# PORTLAND MAINE

RE: Staff Review Comments for Single Family and Level II Site Plans

Project Name: Pomeroy Street Single Family Home & Street Construction      Project ID: 2012-471  
Applicant: Chabad Lubavitch of Maine, Inc.      CBL: 193-E-1  
Planner: Nell Donaldson

SHEET
2

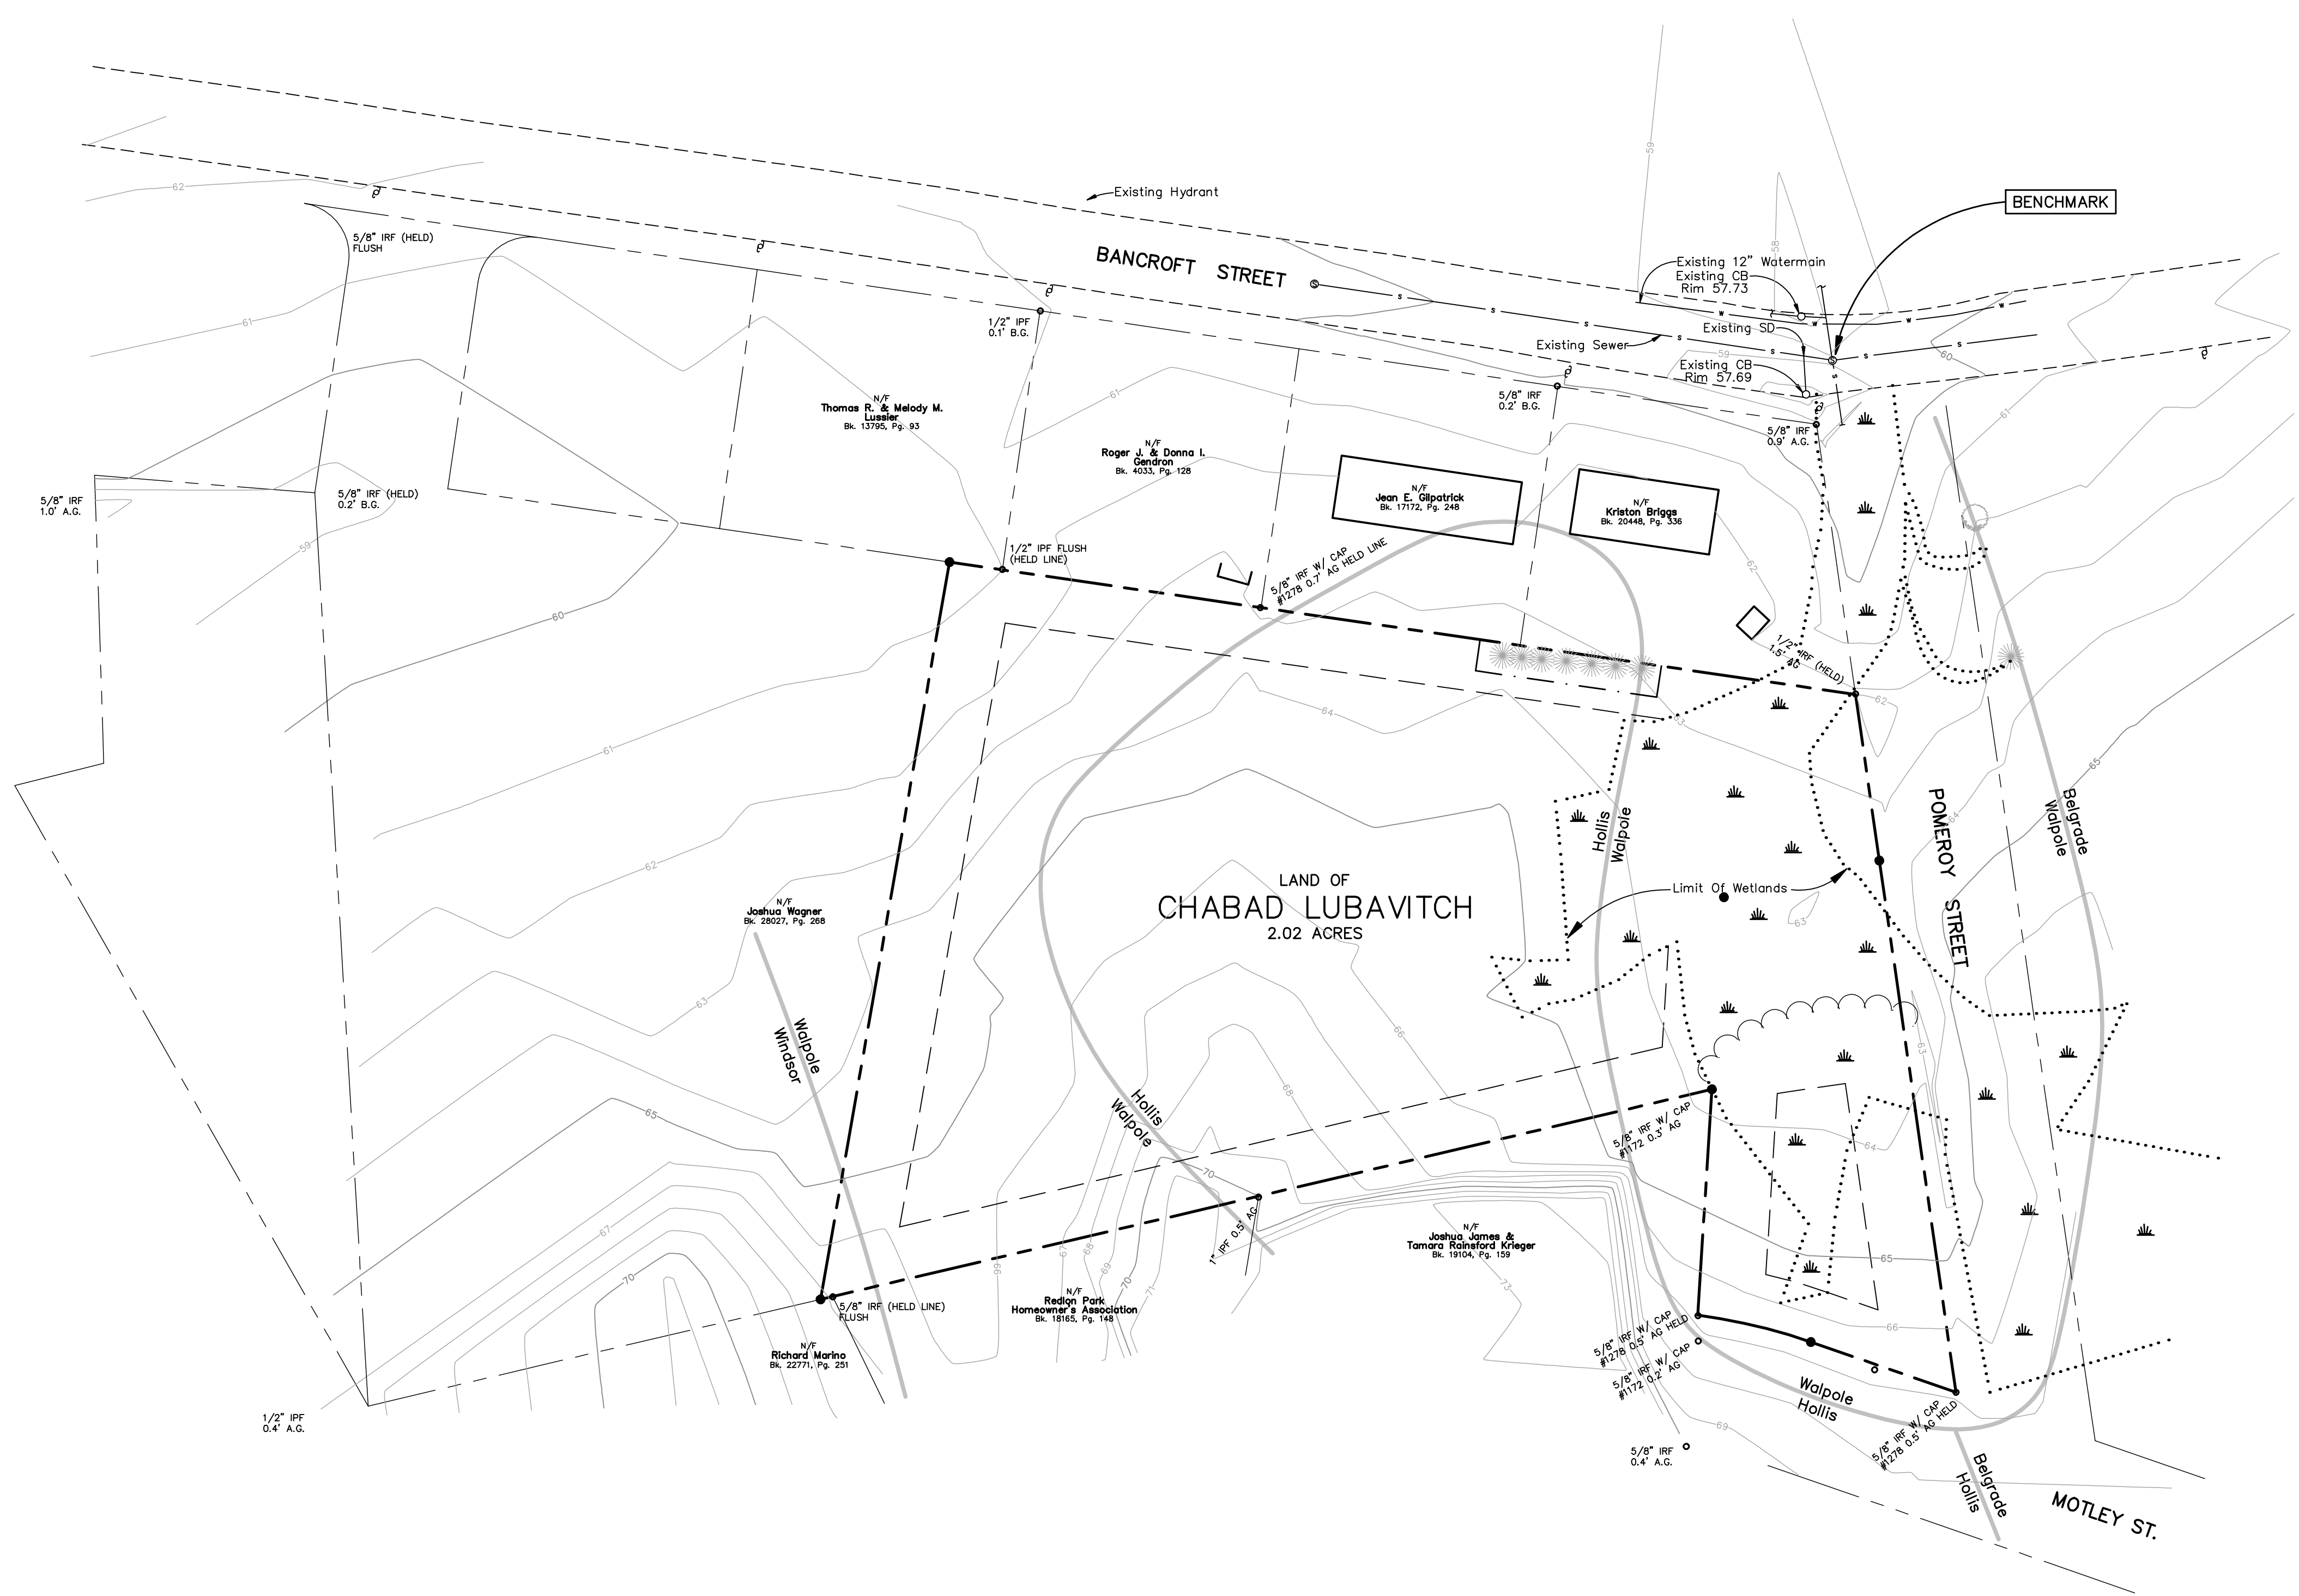
- Please confirm that Kenilworth Street is a paper street. Our records indicate that it has been vacated.
- David Margolis-Pineo writes, *The site benchmark is now on a PK in Bancroft St. What City of Portland benchmark was used to set this benchmark (Note 22)?*

*Bearings and distances are now shown but the information is not clear with all the over writes. A clear separate roadway survey plan for acceptance will be required.*

POMEROY STREET PROFILE
 SCALE:
 VERTICAL: 1" = 5'
 HORIZONTAL: 1" = 25'

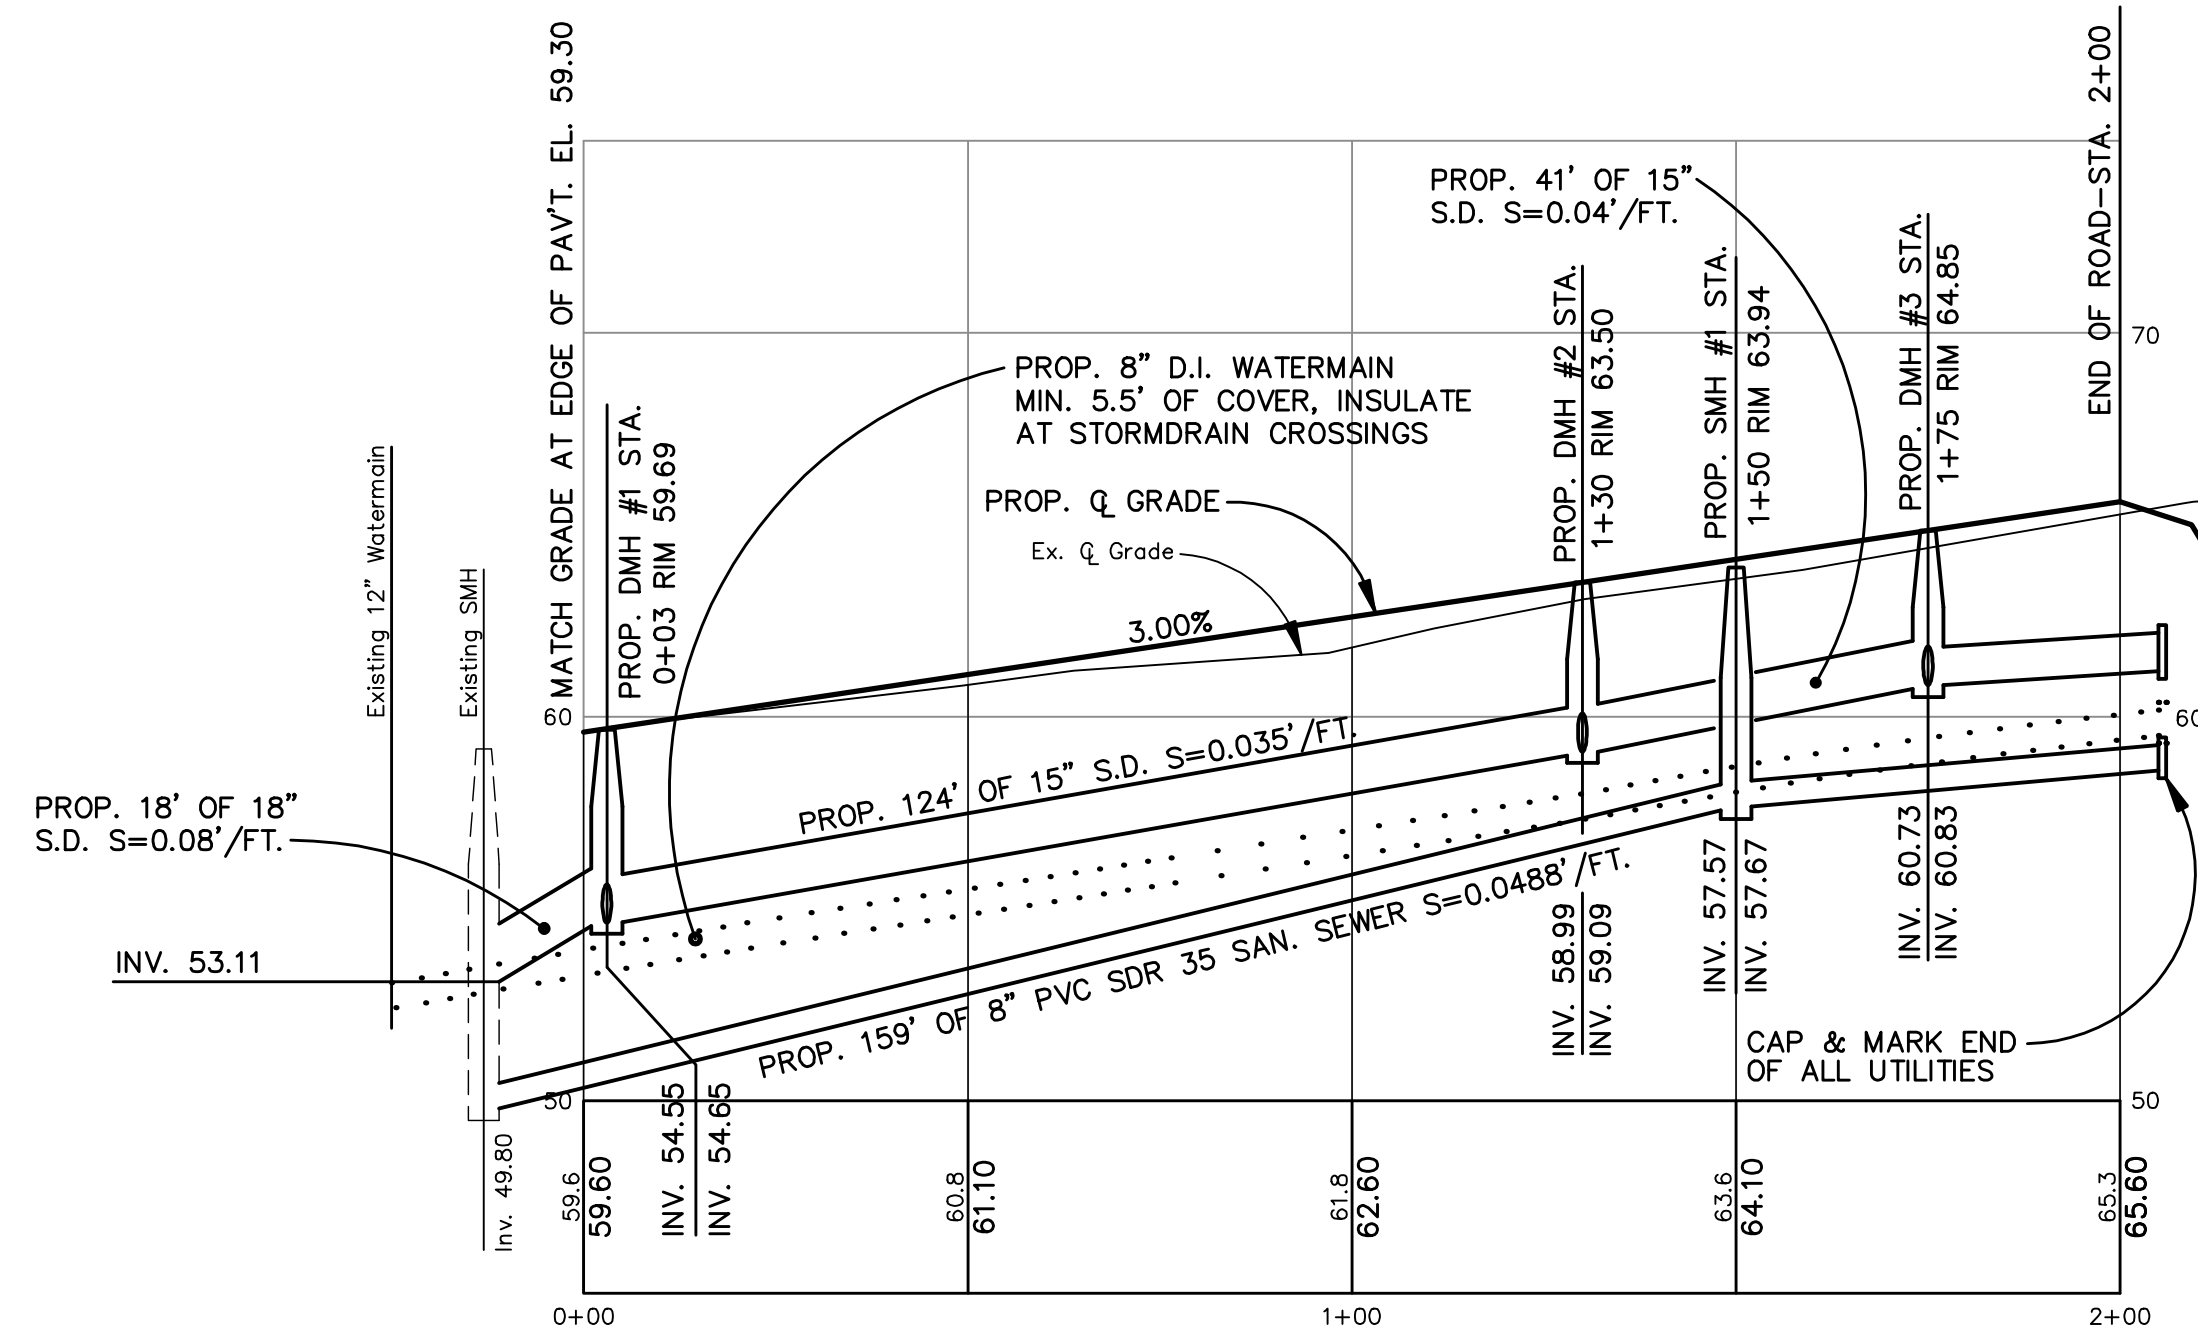
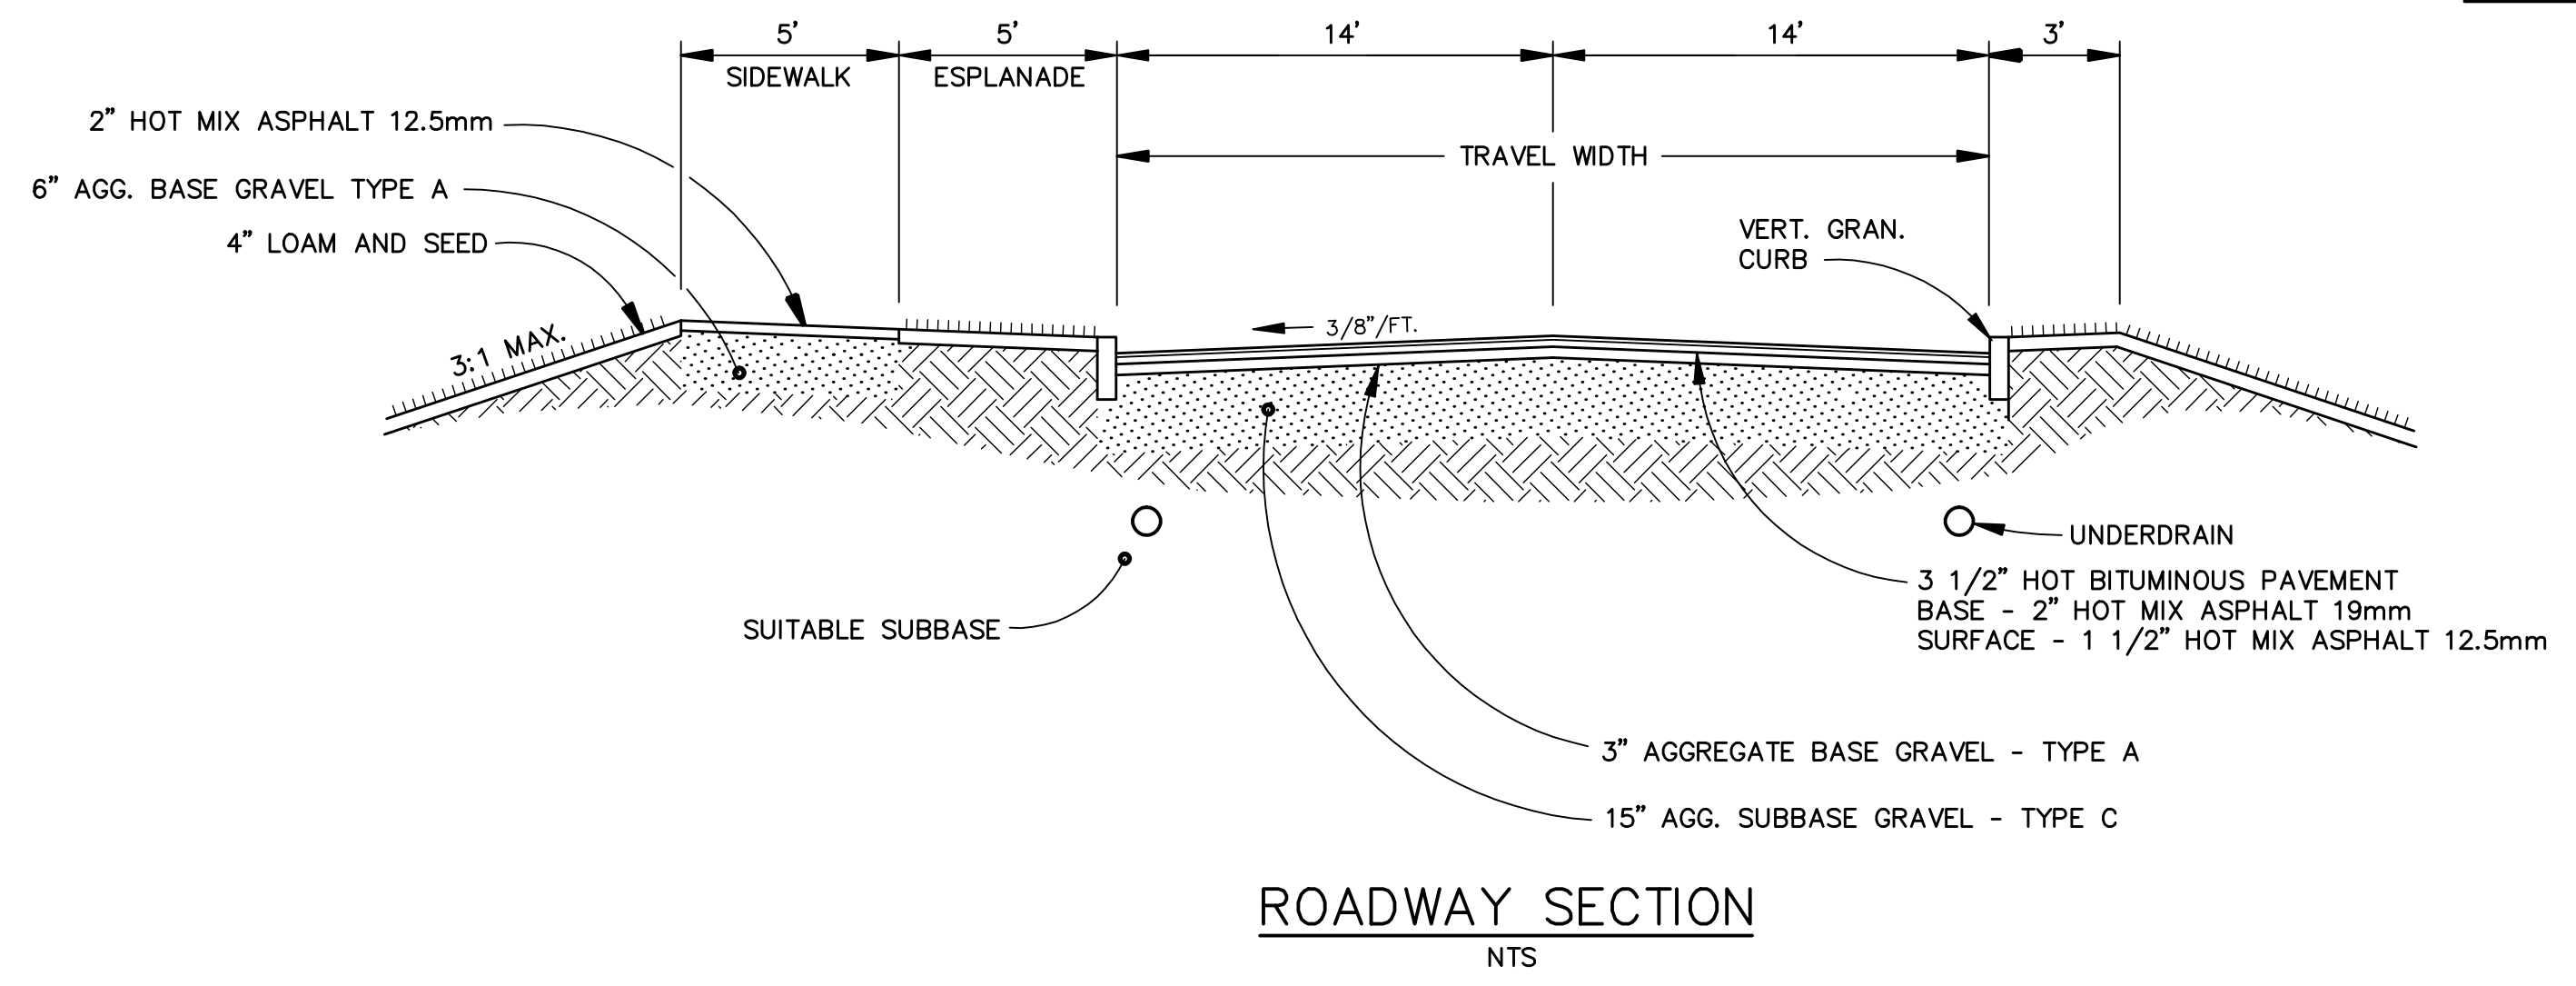
- Per the *City of Portland Technical Manual*, a turnaround is required at the end of the proposed street. The driveway cannot serve this function. Please add a turnaround and define with easements.
- A crosswalk detail, including ADA warning strip, should be provided for review and approval by Bruce Hyman of the City's Department of Public Services.
